## MEMORANDUM

**TO:** Mike Nugent, Portland Code Enforcement  
**FROM:** Joe Hemes  
**DATE:** June 11, 2004  
**PROJECT:** Portland-East End Elementary School  
**RE:** Boca Code Review Meeting June 10, 2004

PROJECT: EAST END SCHOOL
 DRAWING TITLE: REVISED SERVICE AREA & LOADING DOCK

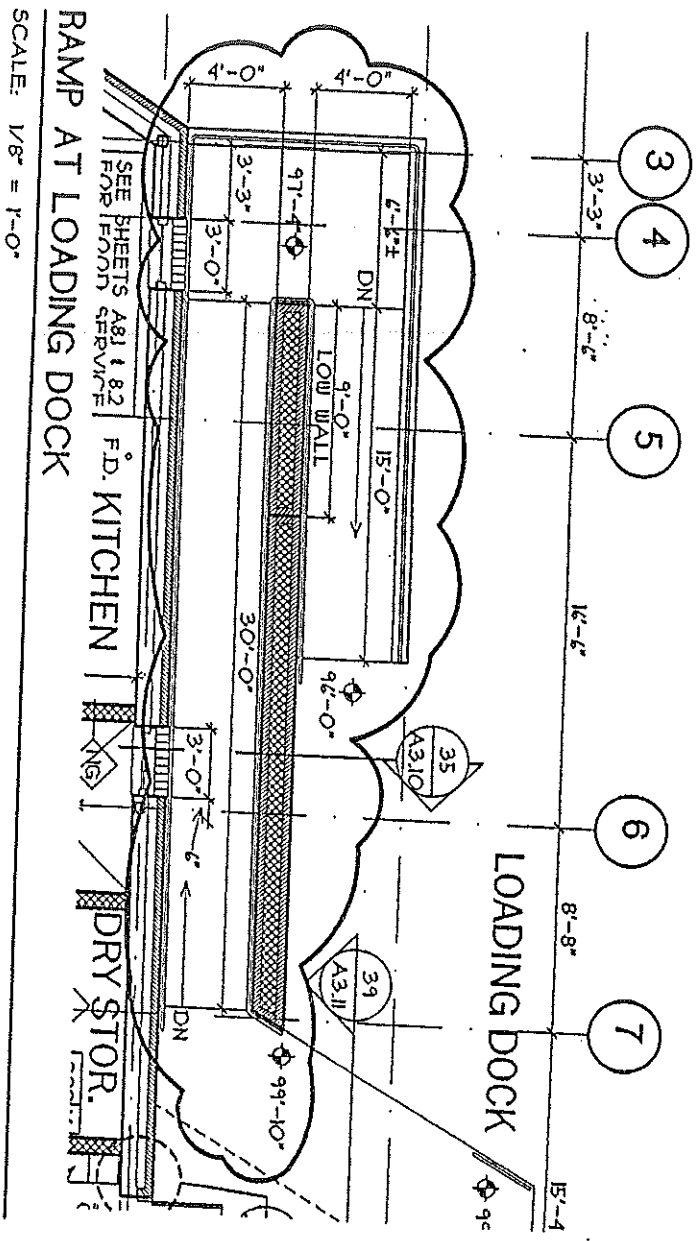
8. The ramp at the loading dock does not need to HC accessible and is sloped 1 to 8. Boca may require 1 to 12 maximum, which would require an 8' longer ramp and switchback. Mike Nugent & Joe Hemes to review.
